Application number: 2026/91492	
What is the application for?:	Demolition of existing garage and erection of replacement garage with two storey
Address of the site or building:	71a, Woodside Road, Beaumont Park, Huddersfield, HD4 5JF
Postcode:	HD4 5JF

User comments

Proposed Plans, Elevations and Block Plan

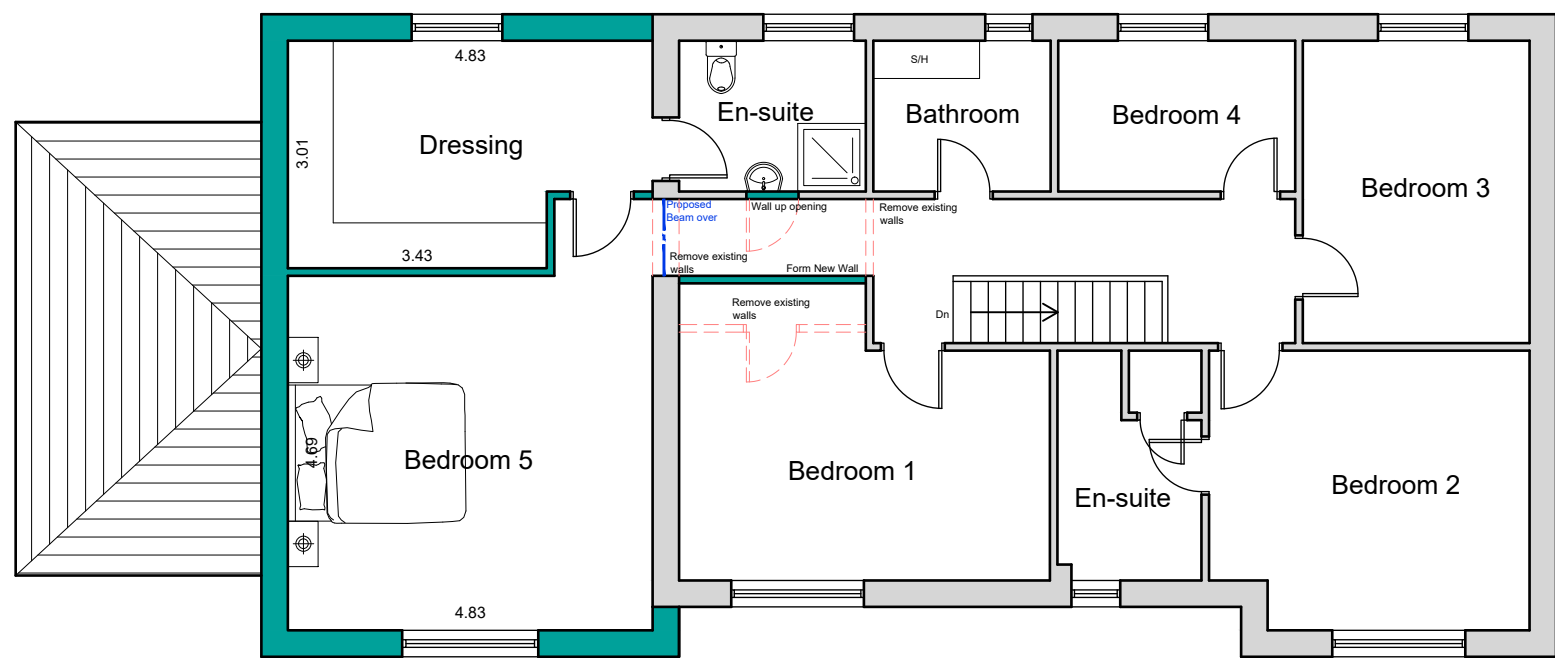
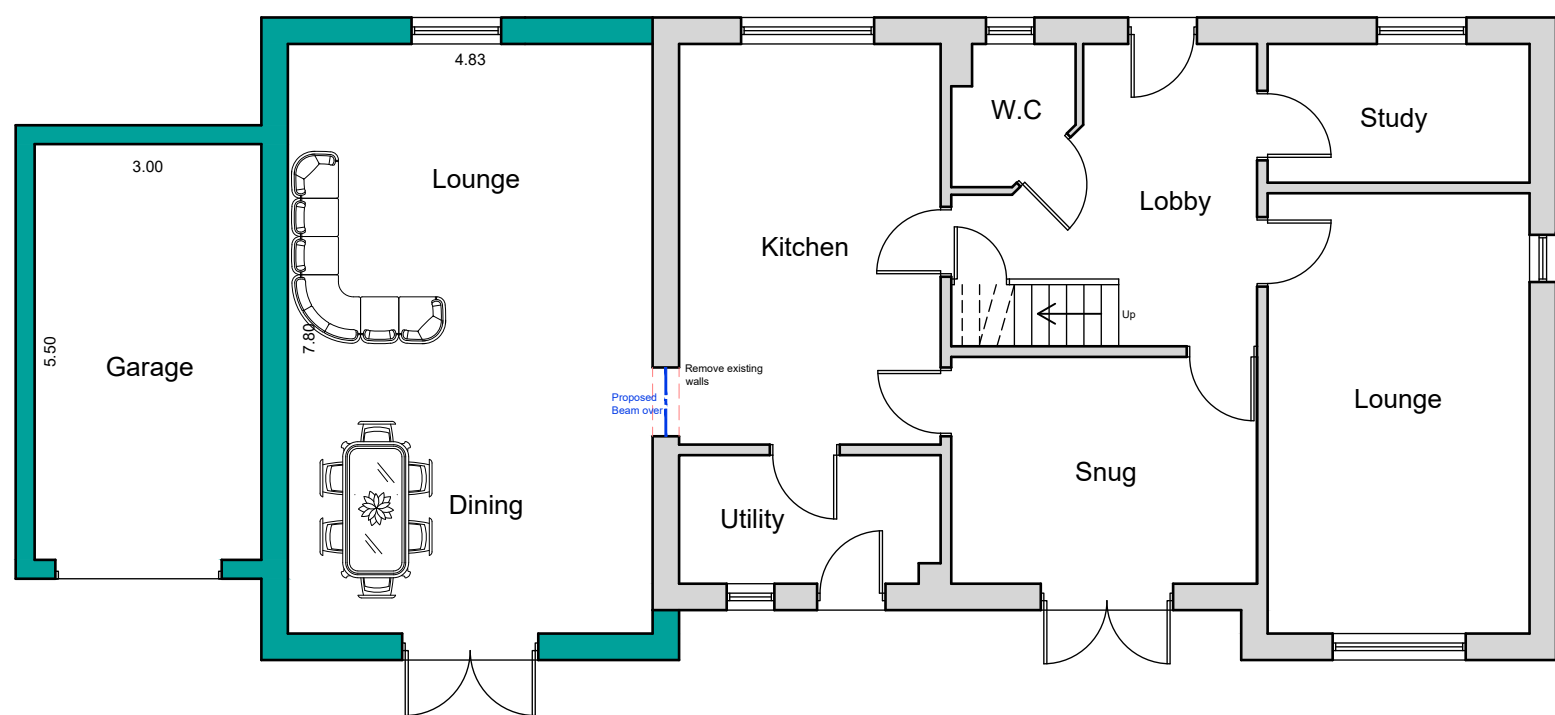
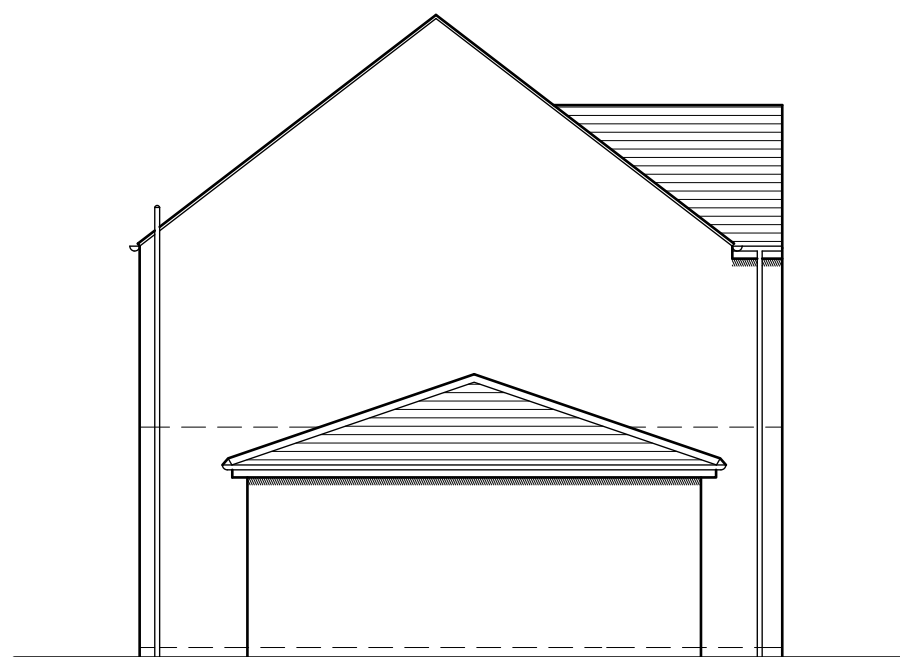
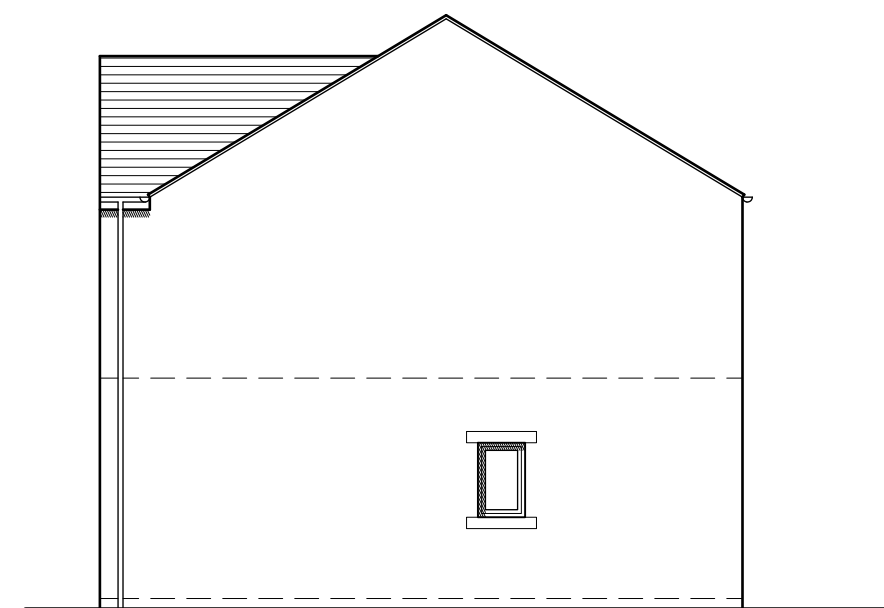
Type of comment: An objection	
Do you wish your comments to be published on the website anonymously?	Yes
The extension is not subservient to the main dwelling and needs to be reduced in size.
